Subject: LU/305/19/RES A2/B6 Hampton Park Toddington Lane Littlehampton BN17 7PL

Neville Wren | Designing Out Crime Officer

RE: Parcel A2/B6 Hampton Park, Toddington Lane, Littlehampton, BN17 7PL. (Not Sent)

Thank you for your correspondence of 18th November 2019, advising me of an 'Application for Reserved Matters following outline permission LU/47/11 for 46 dwellings - this application may affect the setting of a Listed Building - This is a re-submission of LU/379/18/RES at the above location', for which you seek advice from a crime prevention viewpoint.

STREET SCENE A-A

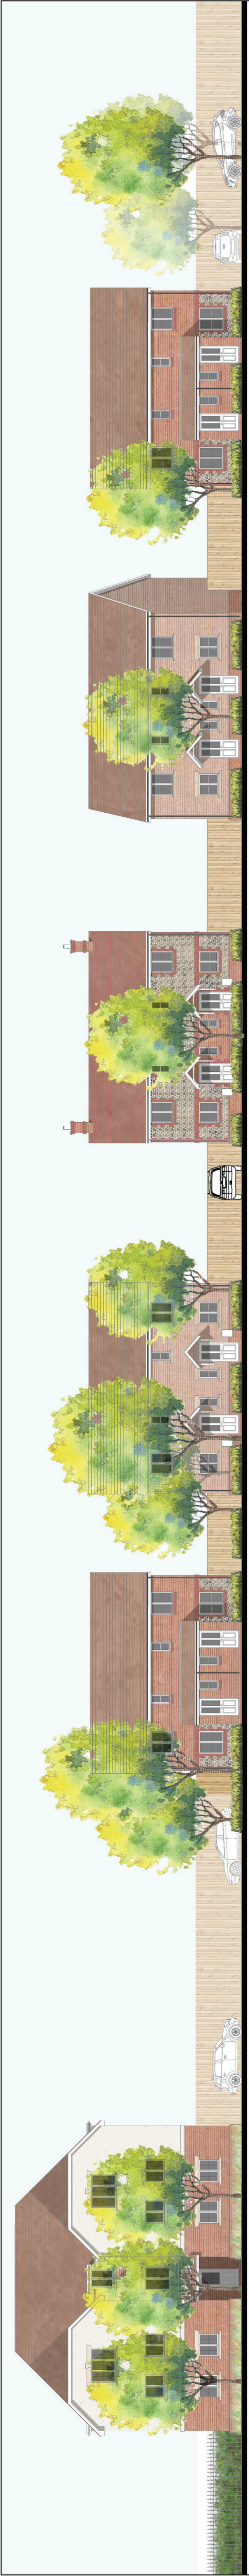
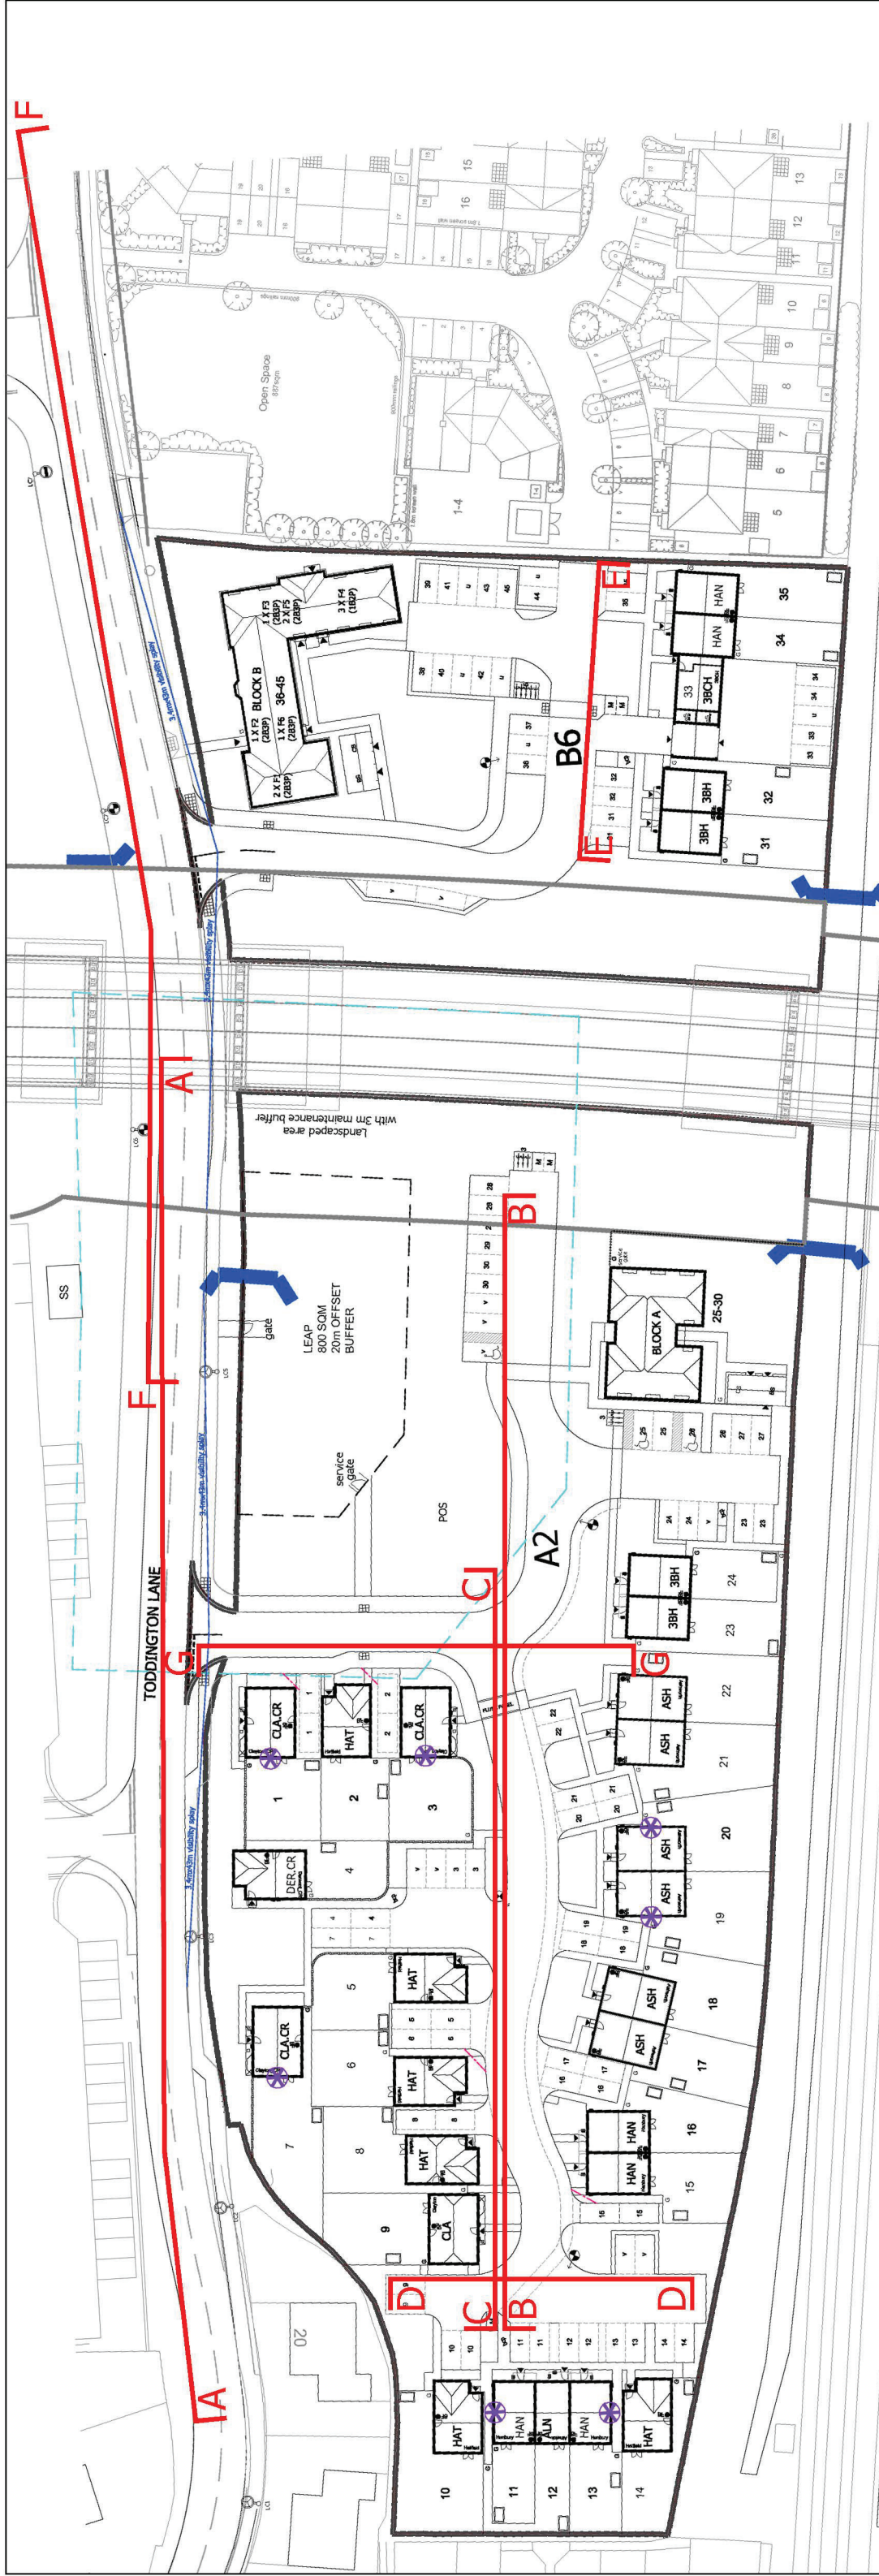
I have a concern that the external visitor cycle storage at the eastern end of the car park of Block A and south of block B are not sufficiently close to the buildings to be easily observed and are vulnerable.

I have a concern that the gate of the LEAP facing Toddington Lane may present a danger to unaccompanied children leaving the area into a potentially busy road. I would recommend a pedestrian barrier opposite the gate, on the pavement, to prevent them running directly out into the road or alternatively relocated the gate.
